Application number: 2026/91485	
What is the application for?:	Re-instatement of previous dwelling with associated alterations
Address of the site or building:	7/9, Track Road, Batley, WF17 7AE
Postcode:	WF17 7AE

User comments

BLOCK PLAN 1:500

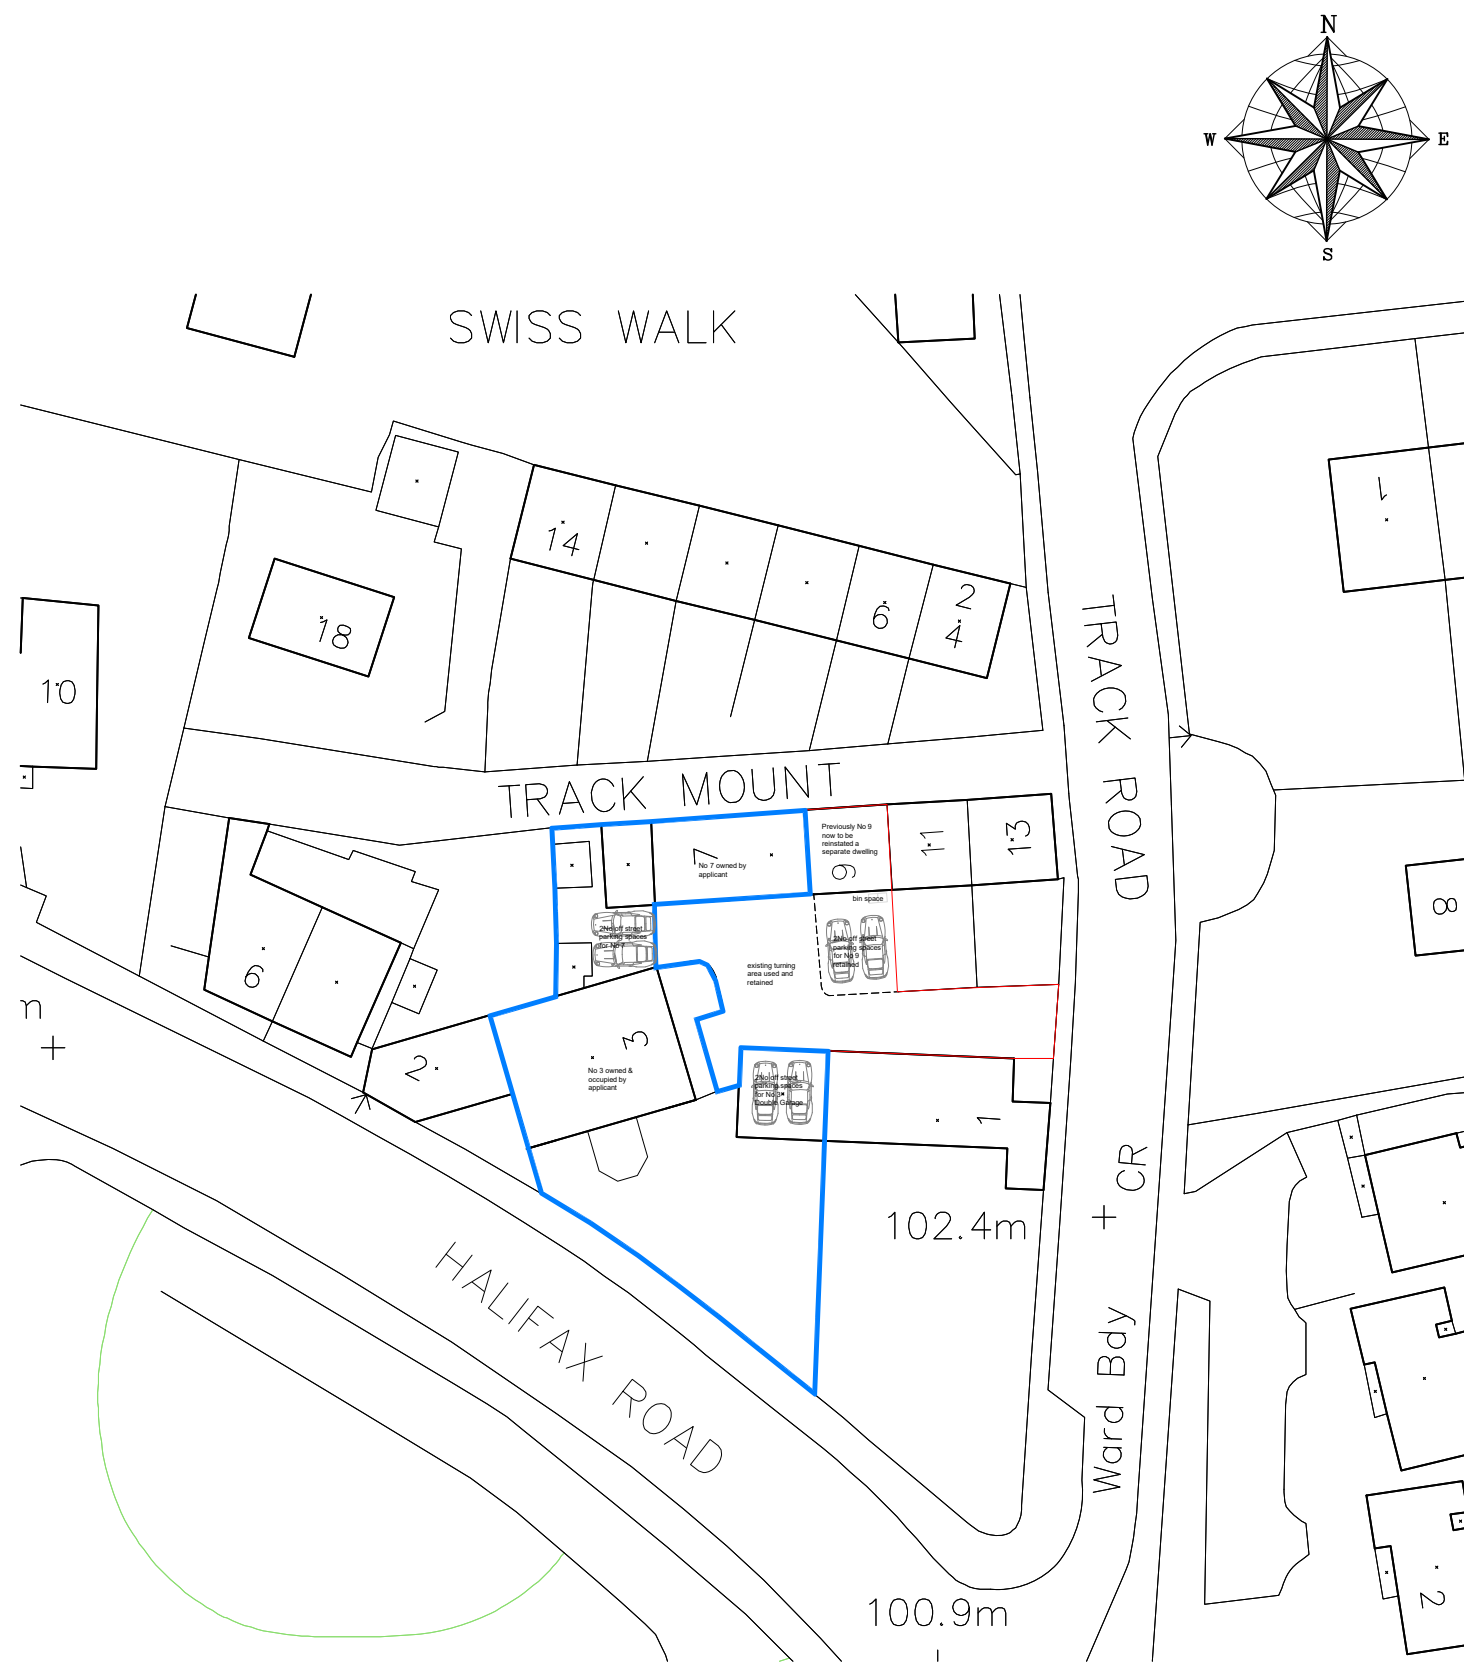
The plans appear to show two car parking spaces available per property; this is inaccurate. There is really only space for one vehicle per household. The bottom of the access road should not be used for parking overflow.
